Mr John Biviano  
120 Darlington Road  
Darlington NSW 2008

**Darlington Terraces Mixed Use Development Application No.: SSD 7539**

Submission

Figure 2: Rooftop Terrace – Building A

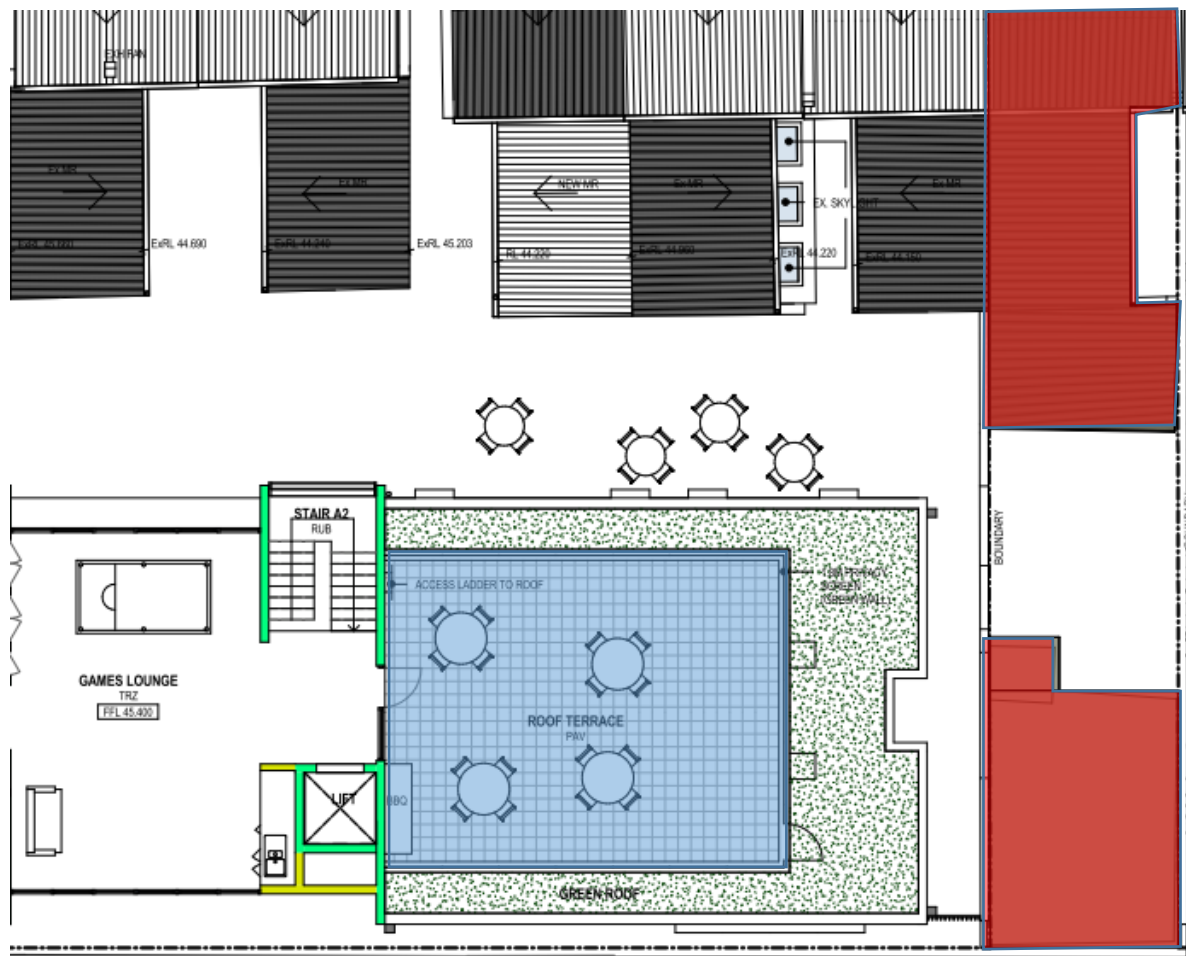
I object to the conditional agreement raised as No. 16 USYD RtS for the EPA (Environment Protection Authority) – page 28. The conditional agreement is unreasonable – the recommendation of the EPA is to ensure that noise does NOT interfere with the comfort and repose of persons not on the development site. The request in this conditional agreement is not conducive for **either** students or residents. If the area in use was a study area (not recreational), then the educational benefits would be apparent. However, this is a **recreational** area, not used for study – the appropriate area for these times would be the proposed indoor study spaces, that unfortunately will not provide enough space for a large number of students.

Students who want to well in their course need and **want** quiet time and place to study away from recreational noise. If other students are in recreation areas at the later times requested by USYD it will not be conducive to their learning. The recommendation from the EPA for less time on weekends and public holidays recognises this. This is where peace and quiet is required for residents and for students to effectively study.

The argument of keeping the same times as other USYD accommodations is unreasonable as none of these developments (Regiment development) are situated as close to the privately owned residences as this development. Also there is, again, no consideration of combined noise from multiple sources. Another oversight that has occurred because the developments are looked at separately and not as a whole.
